Please ask for: Ms Iqraa Malik
Email: iqraa.malik@terraquest.co.uk
Telephone: 0121 234 1390
Our Ref: AW/133/22/HH
Your Ref:
Date: 17th May 2022

Application for Planning Permission for Works or Extension to a Dwelling

Development: Erection of single storey side extension including separate porch following demolition of existing side extension.
This application may affect the character and appearance of the Aldwick Bay Conservation Area.

Location: 15 The Fairway Aldwick PO21 4ES

BLOCK PLAN(1:500)

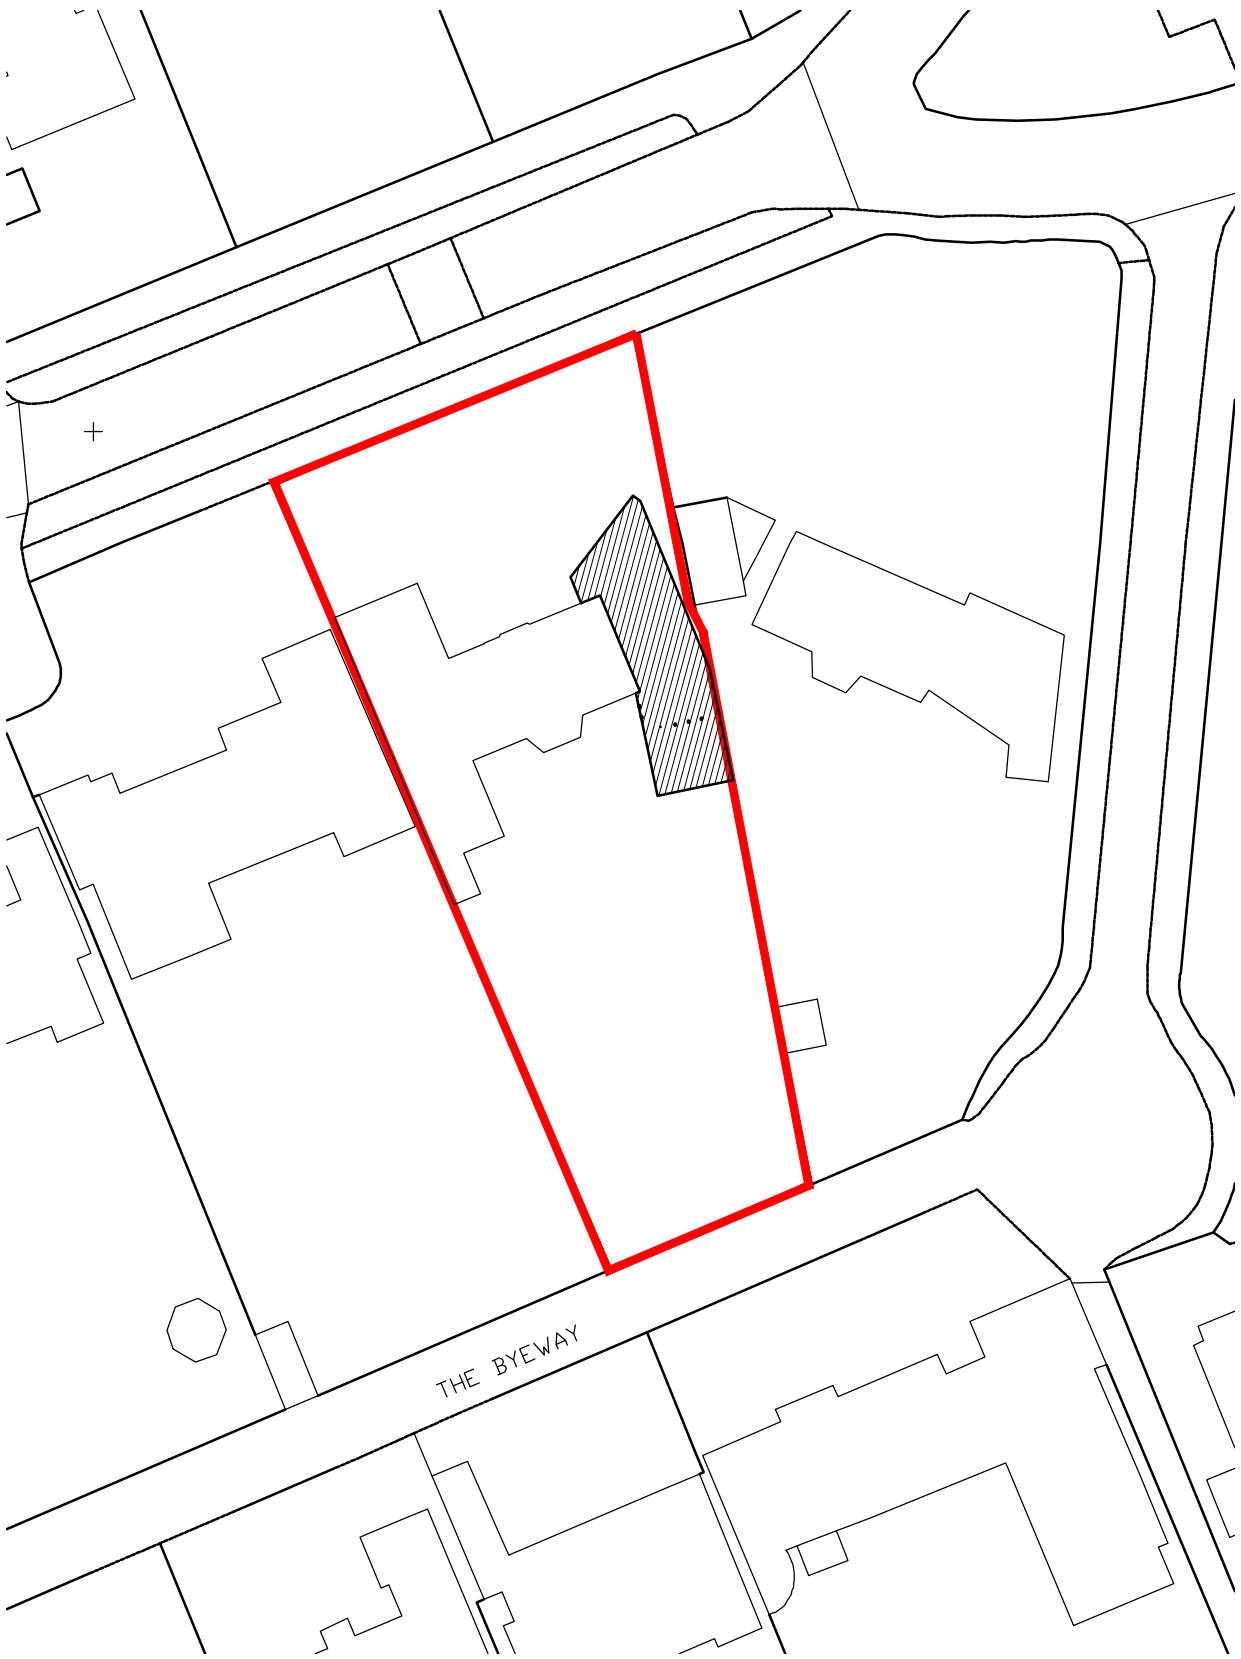
Block Plan

You are required to have dimensions from the proposed extension(s) to all site boundaries. Please amend.
